Ribble Valley Borough Council
Council Offices
Church Walk,
Clitheroe
Lancashire
BB7 2RA

Phone: 0300 123 6780
Email: developeras@lancashire.gov.uk
Your ref: 3/2025/0892
Our ref: 3/2025/0892/HDC/KW
Date: 02 December 2025

Location: 5 Abbey View Whalley Road Billington BB7 9NS
Proposal: Proposed conversion from hairdressers with flat above to dwelling (Class C3) with external alterations.
Grid Ref: 373006 435848

Sheet No.
A105
PROPOSED FLOOR PLANS
Date 03/11/25
Current Revision 7
ISSUED FOR COMMENT

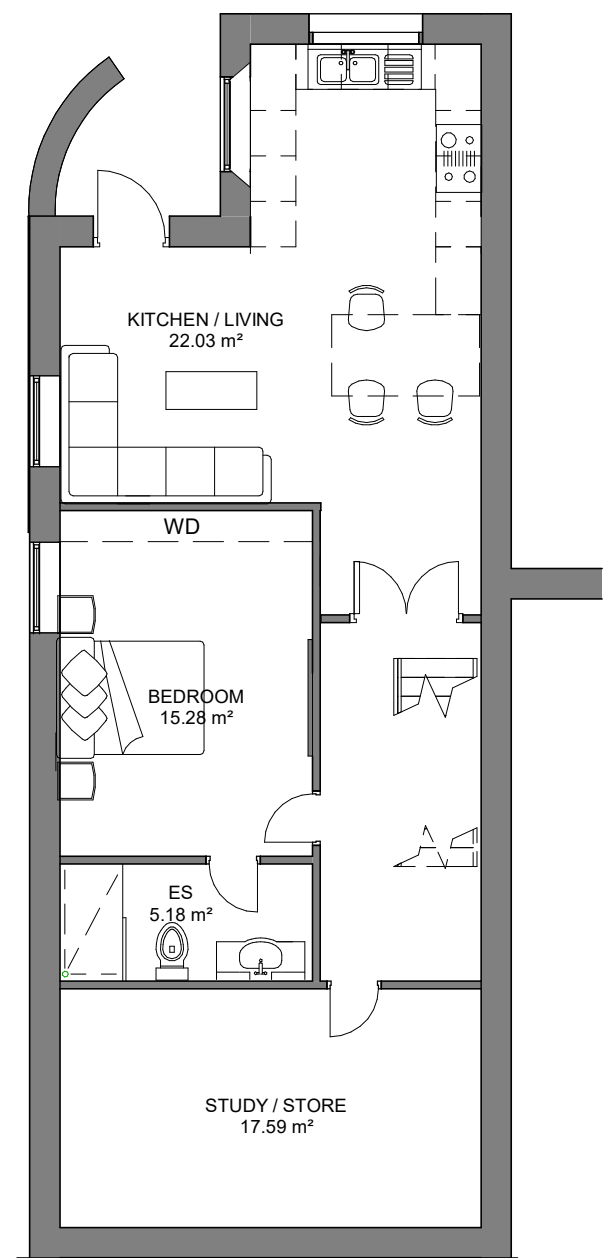
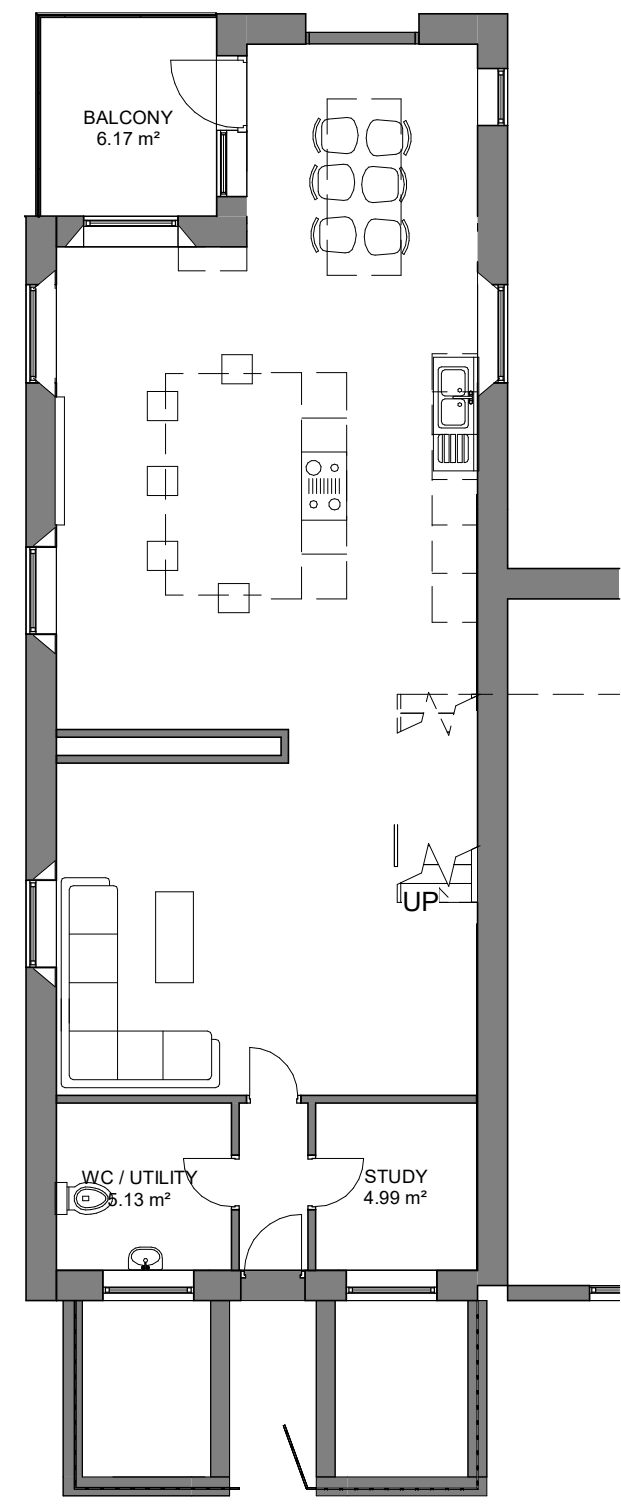
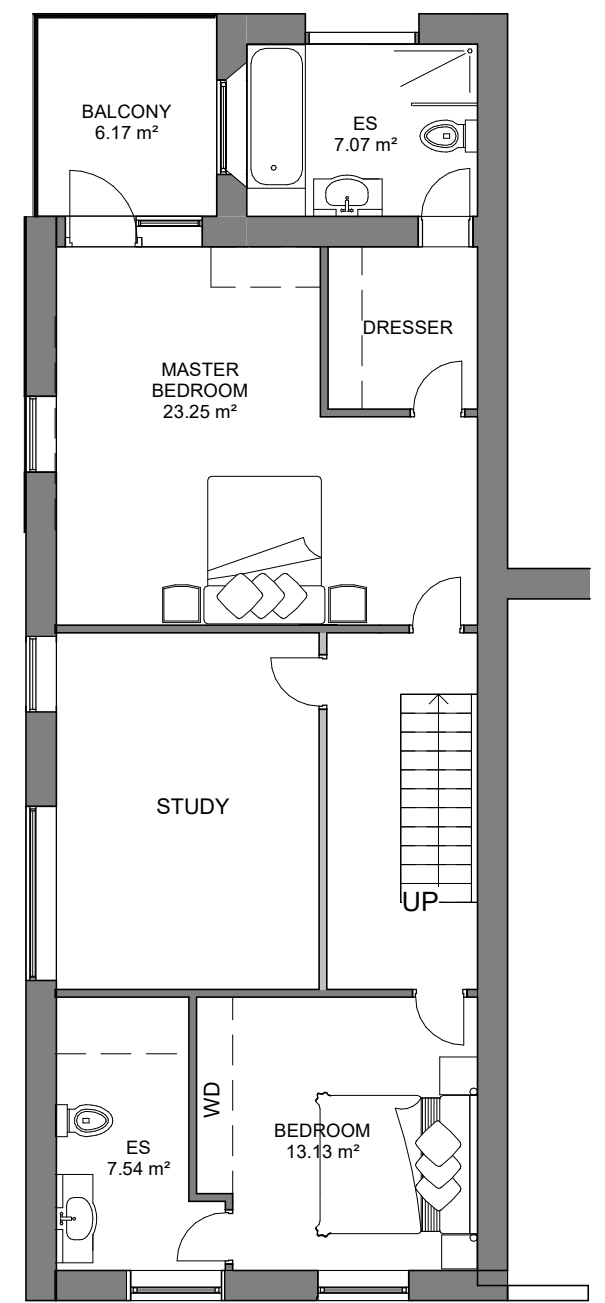
The LHA have reviewed drawing number A107 Rev 7 titled "Proposed Site Plan" and is aware that the dwelling can provide two off-street parking spaces within the existing driveway which is acceptable for a 3 bedroom dwelling. However the internal dimensions of the first-floor study comply with the nationally described space standard for a bedroom. The LHA is of the view that the dwelling could increase the number of bedrooms within the property in the future, which would require a third parking space to be in line with the parking standards as defined in the Joint Lancashire Structure Plan.

The site is in close proximity of bus stops situated on Whalley Road and local amenities are a short walk from the site. There are also parking restrictions on the surrounding roads to control on street parking. The development is also likely to have a lower parking demand than the current use. As such, LHA will accept a shortfall in off-street parking provisions. It is also likely that on-road parking for a third vehicle can be accommodated without being detrimental to highway safety or capacity.
